Please ask for: Ms Iqraa Malik
Email: iqraa.malik@terraquest.co.uk
Telephone: 01212341390
Our Ref: AW/161/20/HH
Your Ref:
Date: 15th July 2020

Application for Planning Permission for Works or Extension to a Dwelling

Development: Two storey residential side extension
Location: 34 Wakefield Way Aldwick PO21 3RS

Block Plan

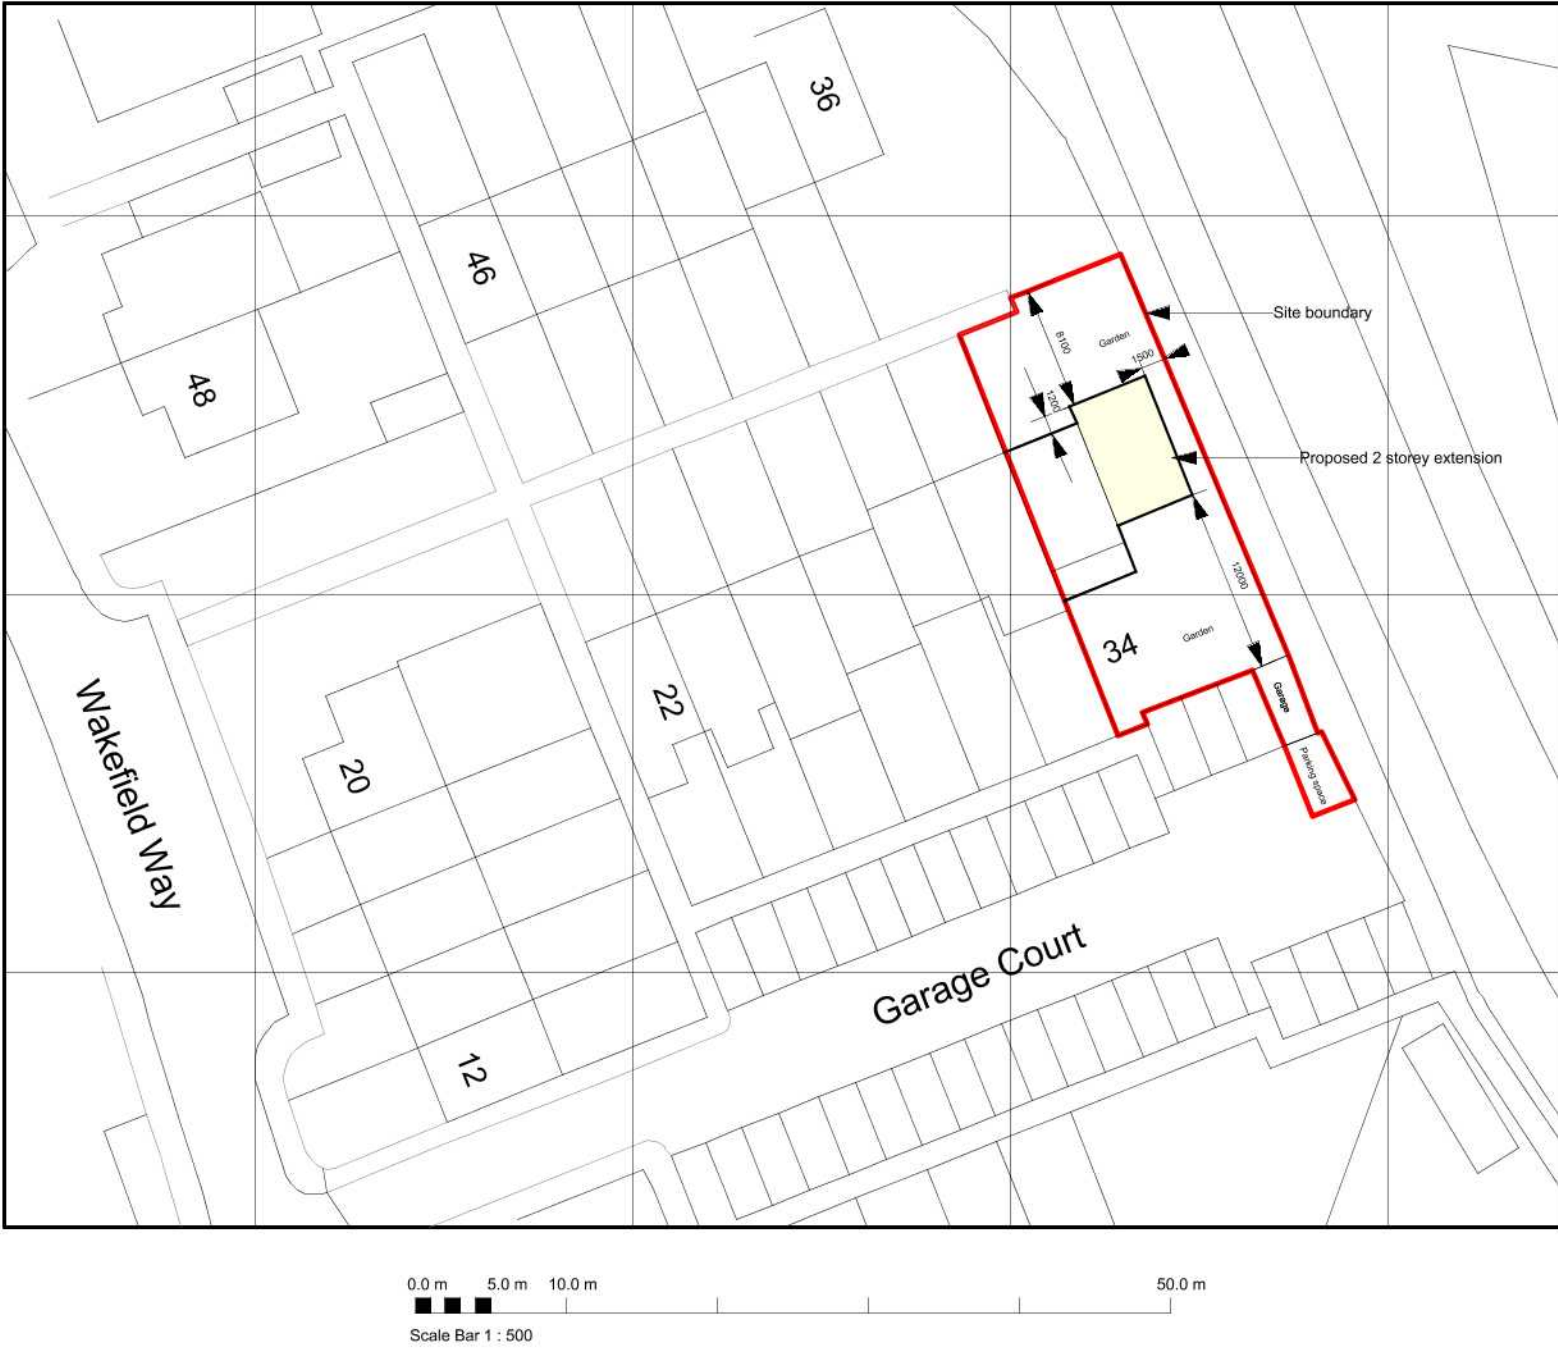
You are required to have dimensions from the proposed extension(s) to all site boundaries. Please amend.

IVON BLUMER ARCHITECTS LTD			
PROJECT	Wakefield Way	DATE	06/07/19
TITLE	Proposed Plans	DRG NO	IBA/520/03
SCALE	1 : 100	REVISIONS

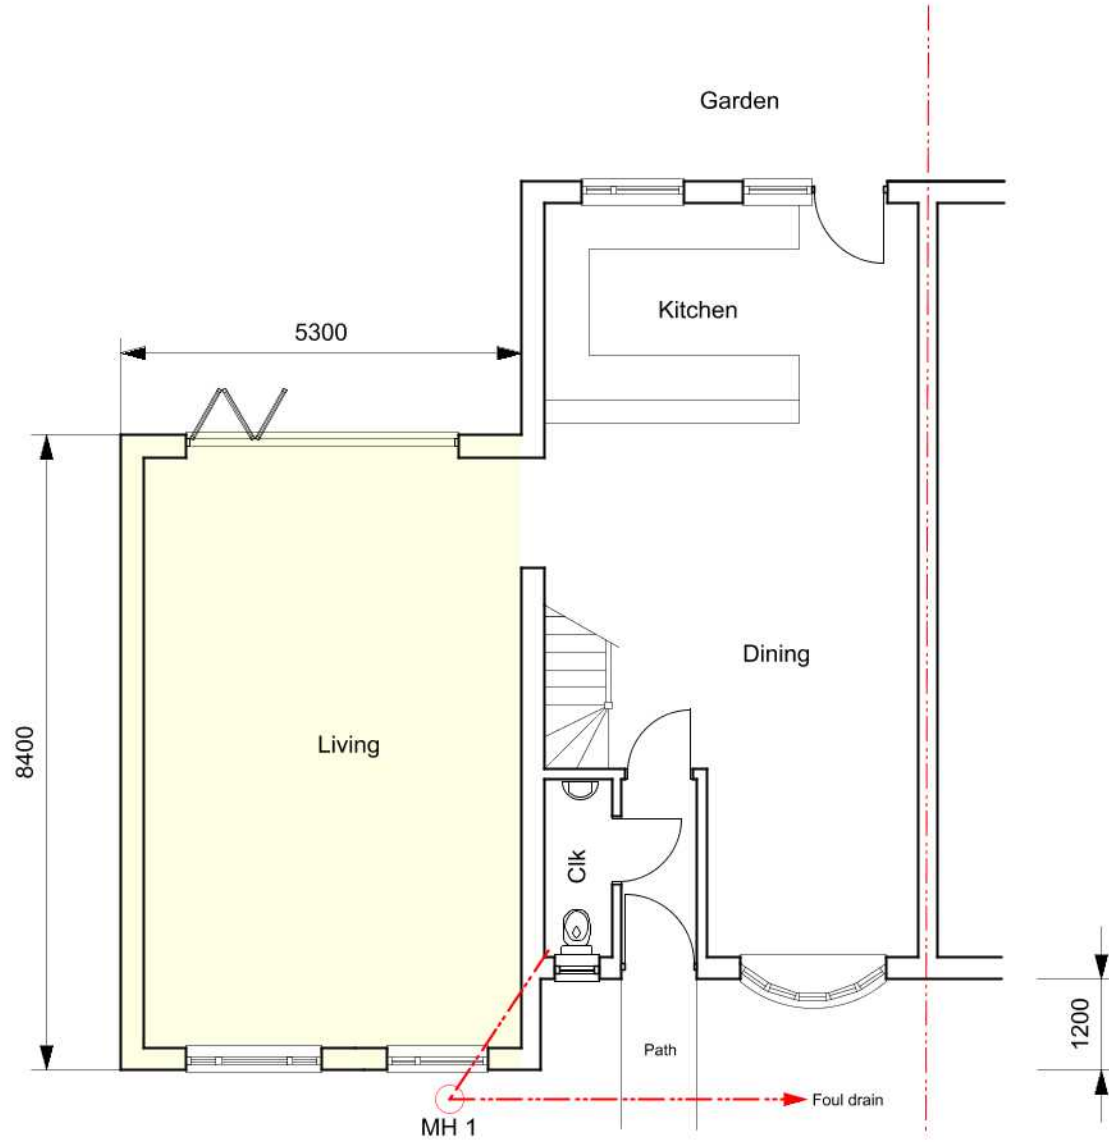
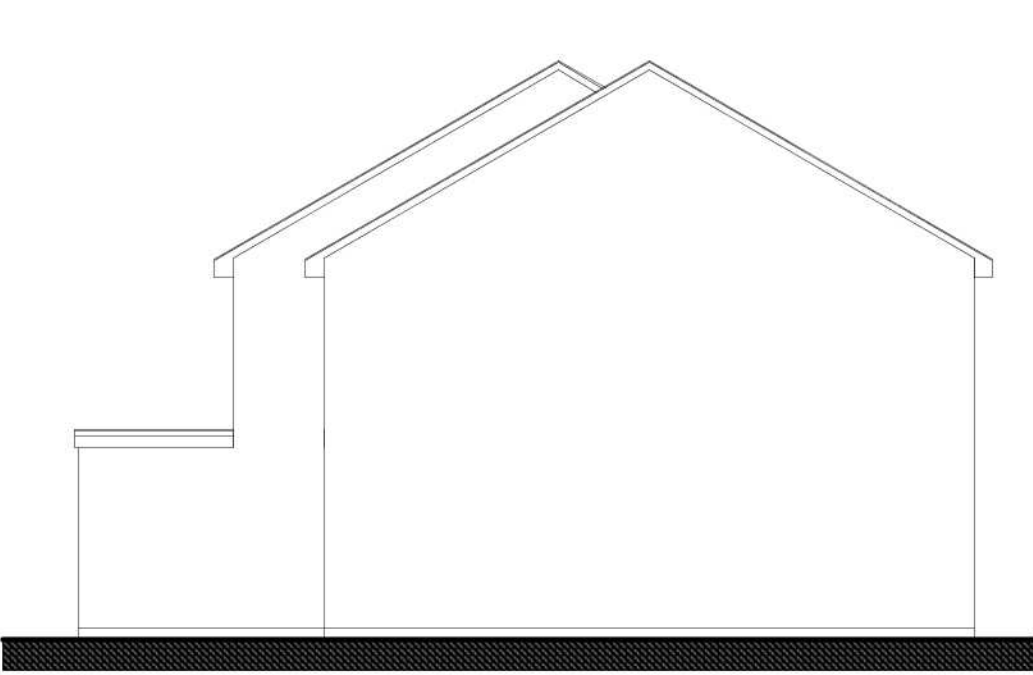
The building line between the ground floor plan and the side elevation is inconsistent. Please amend.

The proposed plans aren't measuring to the scale you submitted. Please amend.

Proposed Side Elevation East

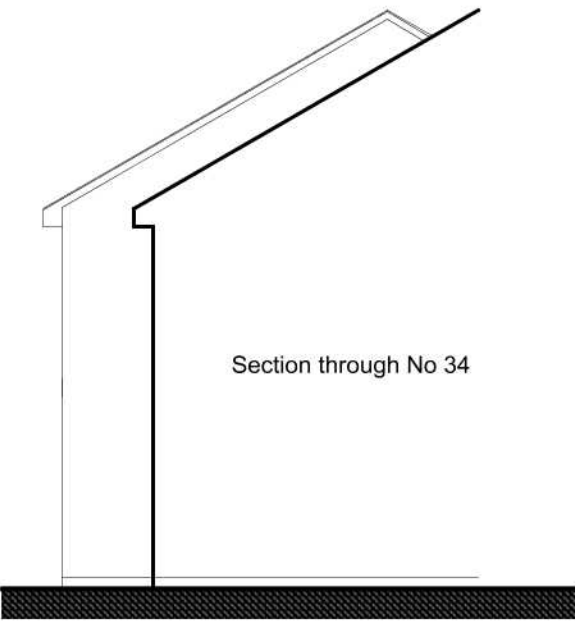
Please submit the other side elevation.
